OUT21/2138

**Snowy 2.0 - Transmission Connection (SSI-9717)
EIS**

Liz Rogers
Manager, Assessments, Knowledge Division
Department of Planning, Industry and Environment: Water
26 March 2021

Figure 5-1 | Waterways and monitoring locations

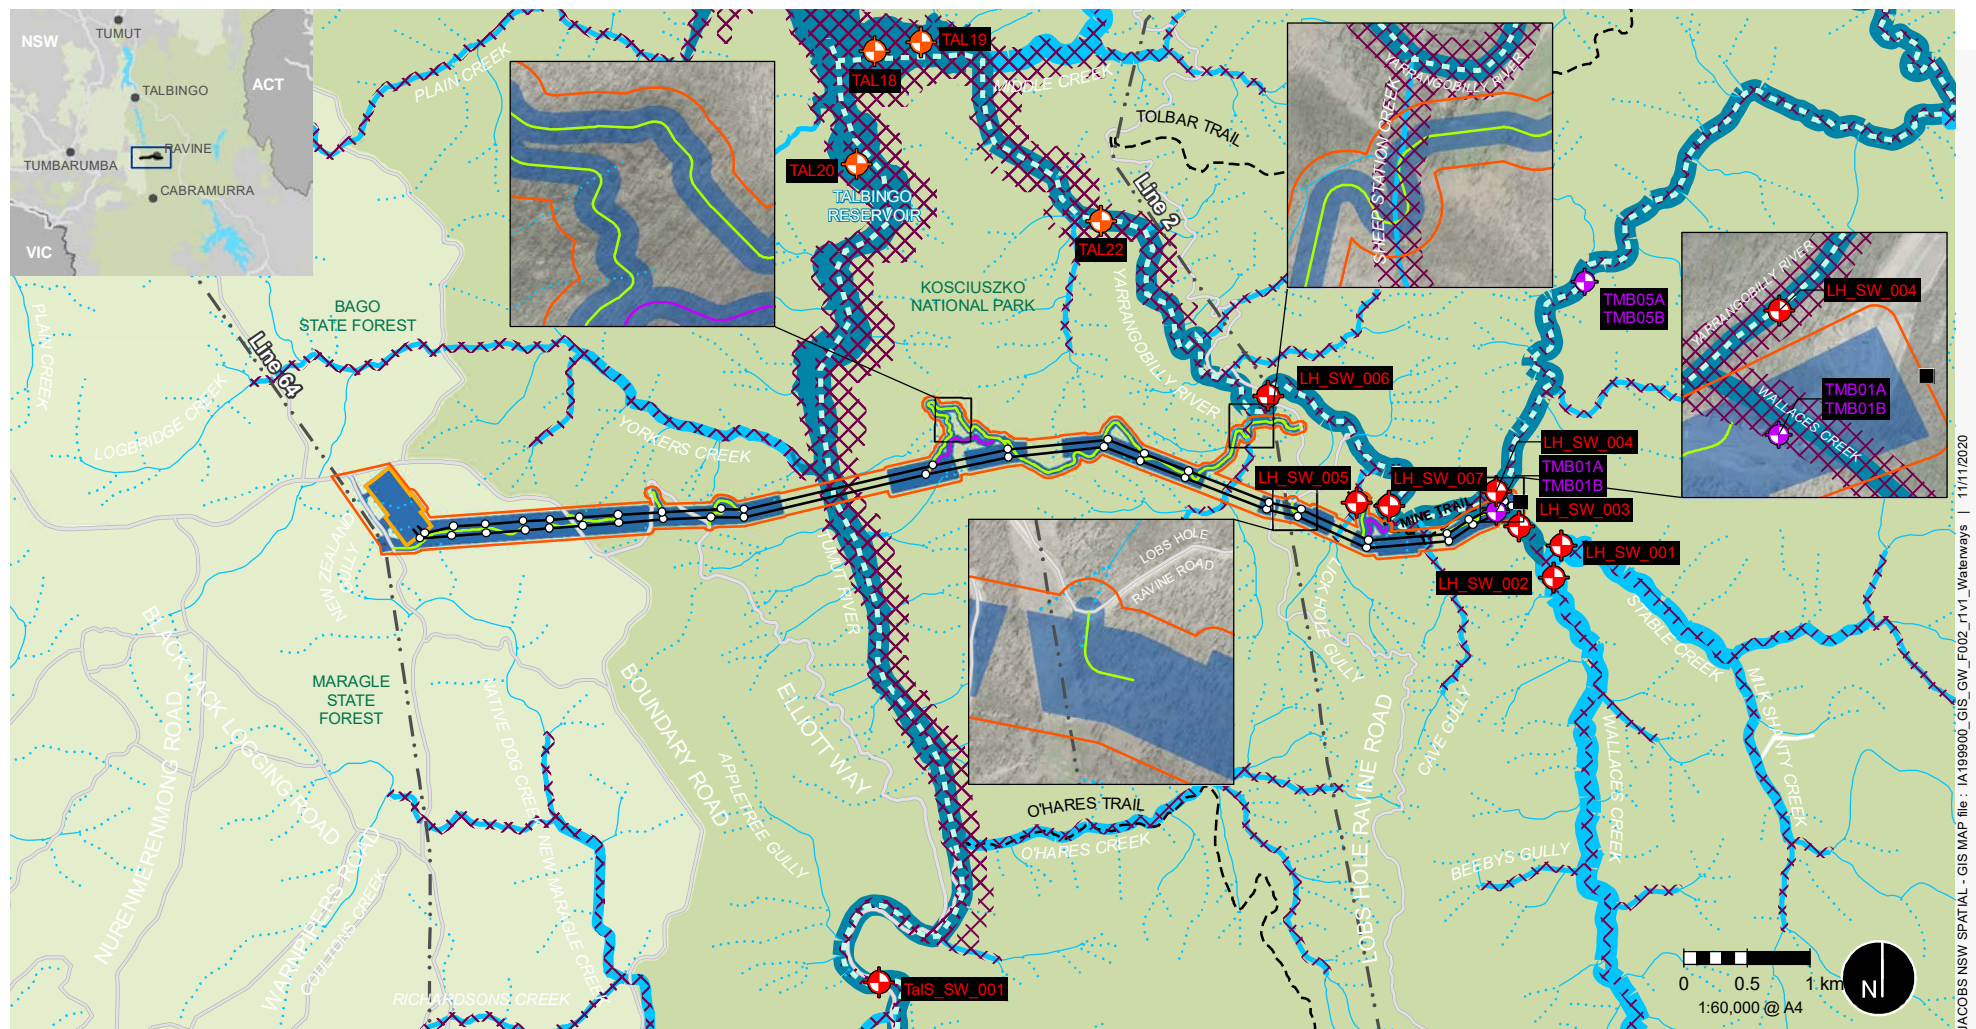
- Detailed design, construction and rehabilitation of works within waterfront land needs to address the requirements of the *Guidelines for Controlled Activities on Waterfront Land* (NRAR 2018). This should include the proposed watercourse crossing of Sheep Station Creek, in addition to disturbance near or within watercourses within the broader transmission corridor.

- Stream crossing design should include standard measures to protect water quality and stream function.
Appropriate measures are outlined in the following documents:
 - Forest Soil and Water Protection – A Guide for Operators, State Forests of NSW 2000, pp 35-38.
 - NSW RFS (2017) Fire Trail Design, Construction and Maintenance Manual
 - Water sensitive design for rural subdivisions – WaterNSW
- Groundwater dependent ecosystems (GDEs) have been recognised along the proposed route of the transmission line and support tracks. These are mostly water course crossings and Alpine/sub-alpine fens. The proponent should undertake suitable studies of proposed positions of transmission towers and vehicular access to avoid, manage and mitigate impact to alpine fens or other Plant Community Types (PCT) or GDE's along the proposed alignment.
